Address: 82 Jenkyn Lane Huddersfield HD8 8AW

Application number: 2024/90561	
What is the application for?:	Erection of side and rear extensions with associated alterations
Address of the site or building:	82, Jenkyn Lane, Shepley, Huddersfield, HD8 8AW
Postcode:	HD8 8AW

PROPOSED SITE PLAN 1:500 @A4

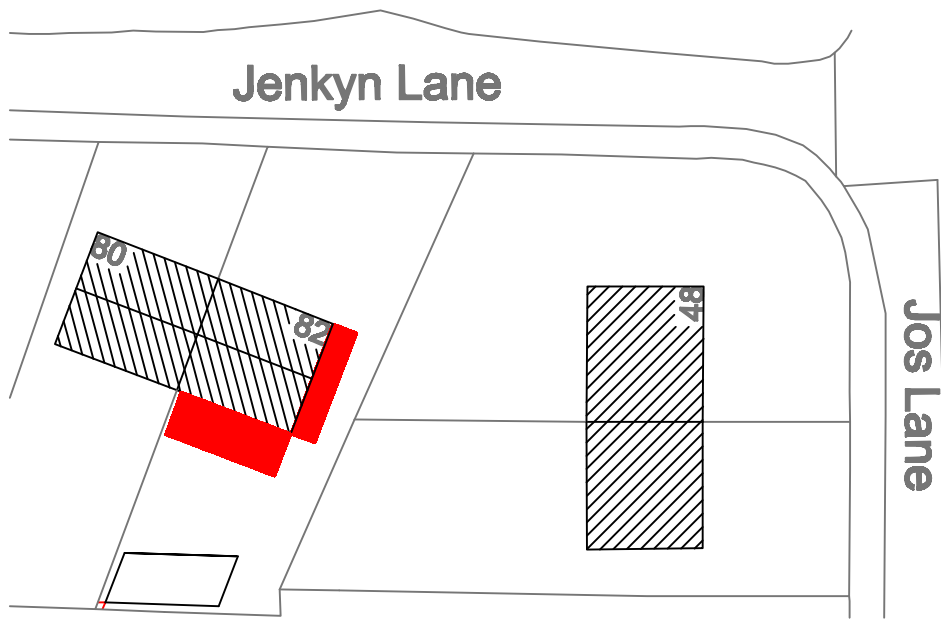
Type of comment: An objection	
Do you wish your comments to be published on the website anonymously?	No
<p>I am concerned about the overall scale of this development which would totally overwhelm the surrounding properties. The side extension would come to within 1 metre of the boundary and plans show this as a gable wall, not a 'hipped' roof, which given the differential in ground levels would be tantamount to having a 3 storey wall some 1 metre away.</p> <p>The size and scale of these proposals would have a major impact and block out a significant amount of daylight and sunlight from our property.</p> <p>The bedroom window shown on the first floor would mean that we were completely overlooked and remove all privacy. Similarly with the proposed balcony to the front this would again affect our privacy, being overlooked.</p> <p>The design deviates from neighbouring and surrounding properties, which are 'hipped' roofs and is therefore totally out of keeping. Given that this property is on the edge of the village and is clearly visible on the approach, the design would have a significant impact on the character of the area.</p> <p>The size and style of this development would have a detrimental effect on this area of the village.</p>
